Subject: FW: Planning Consultation on: LU/144/22/DOC - Condition 7 - Construction Management Plan.

I refer to Construction Environmental Management Plan (Framework) DOC: LTH-RGP-SW-XX-RP-Y-XX-6809 (P05), dated May 2022. I make the following comments:-

Application No: LU/144/22/DOC

Description of Works: Approval of details reserved by condition imposed under ref LU/116/21/PL relating to Condition No 7 - Construction Management Plan.

APPENDIX C

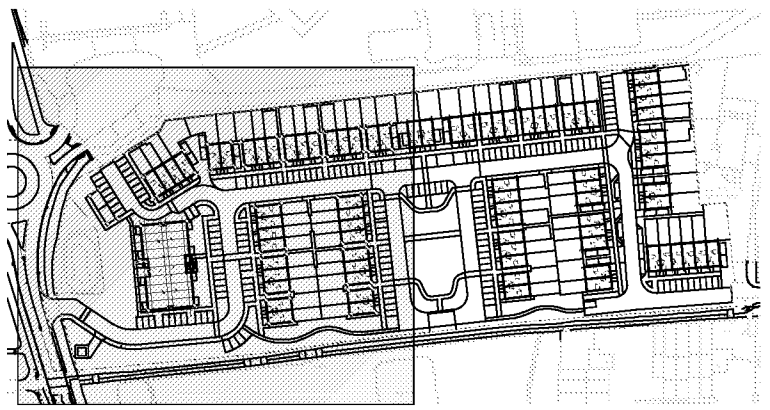
1.3.2 /4.2.1(vii)/4.5. Any site compound to be sited away from nearby sensitive receptors.

3.1.8. Haul road. The haul road should be moved away from the site of Littlehampton Day Nursery, which generally has lack of consideration in this document.
